April 20, 2023

Subject: Dawson Pool House
565 Cotton Road
Fuquay Varina, NC 27526
Plan Revision Letter
Harnett County Permit #: BRES2211-0021

A2 WALL SECTIONS
04 NTS

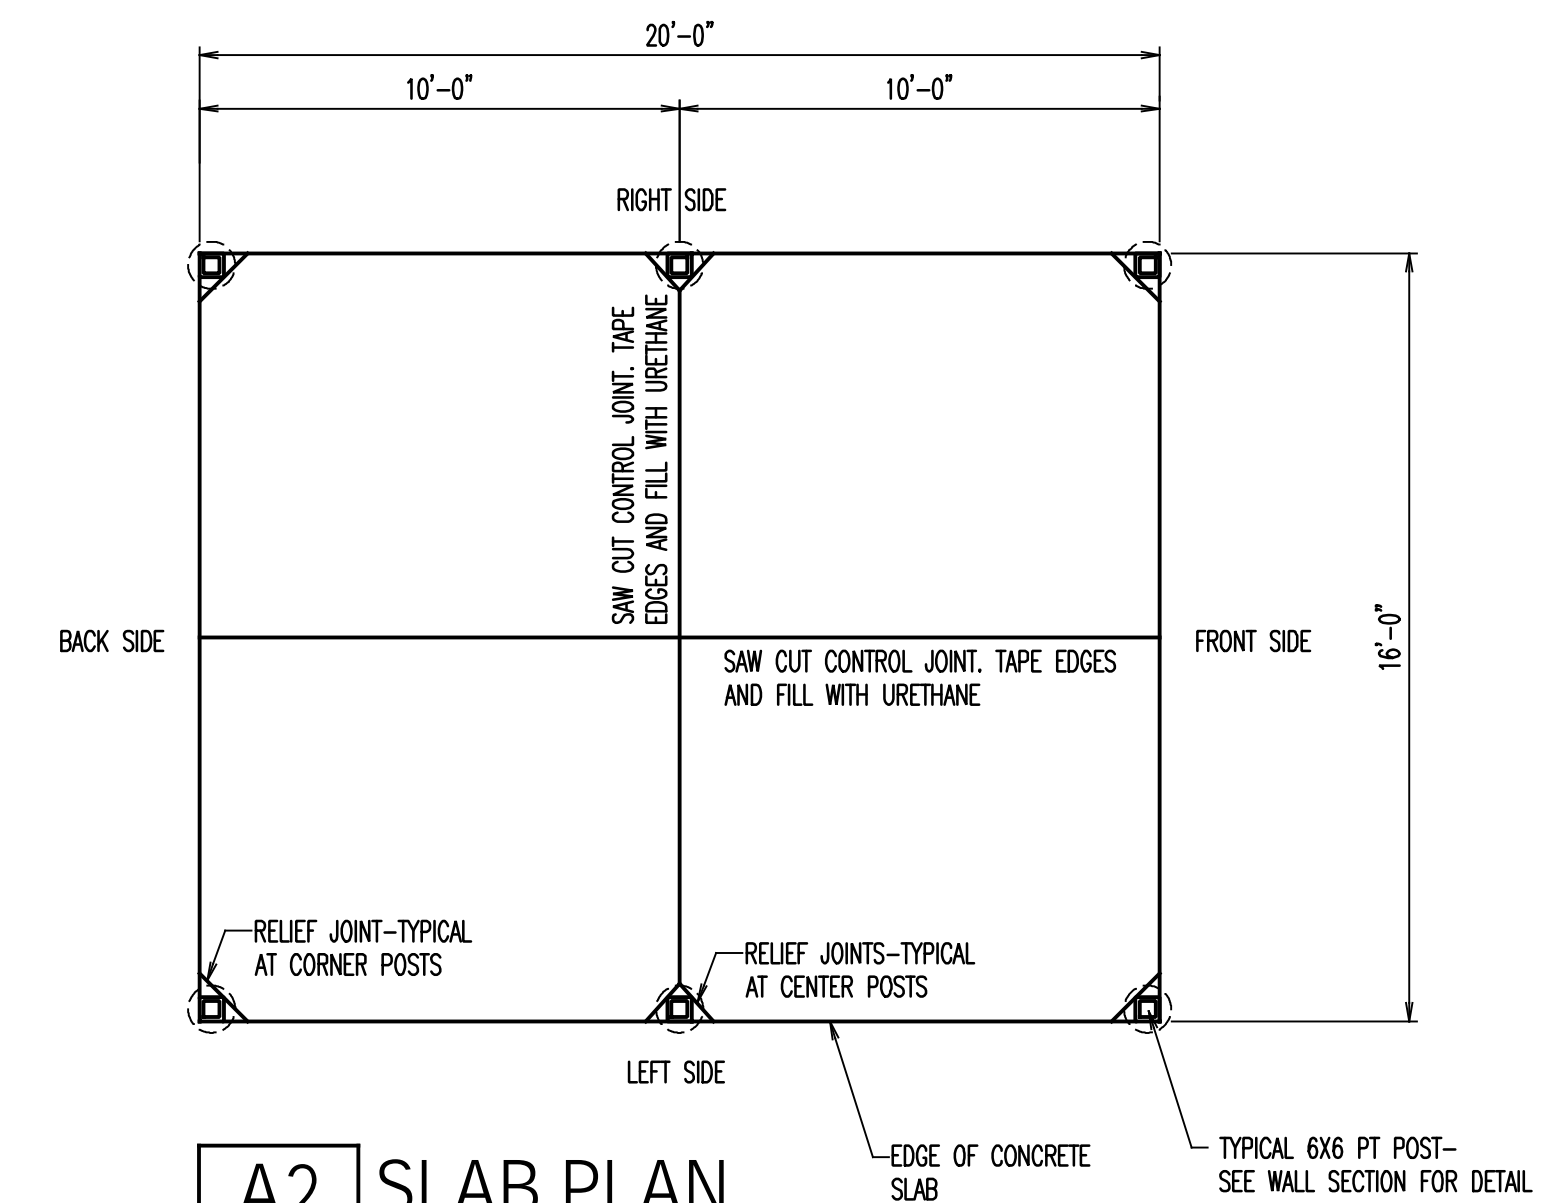
- The Contractor wants to move the ceiling joists up to attach to the rafters. The ceiling joists have been moved up and attached to the rafters. The revised location and installation of the ceiling joists is acceptable.

The ceiling joists noted above meet all the requirements of the 2018 North Carolina Building Code for Residences.
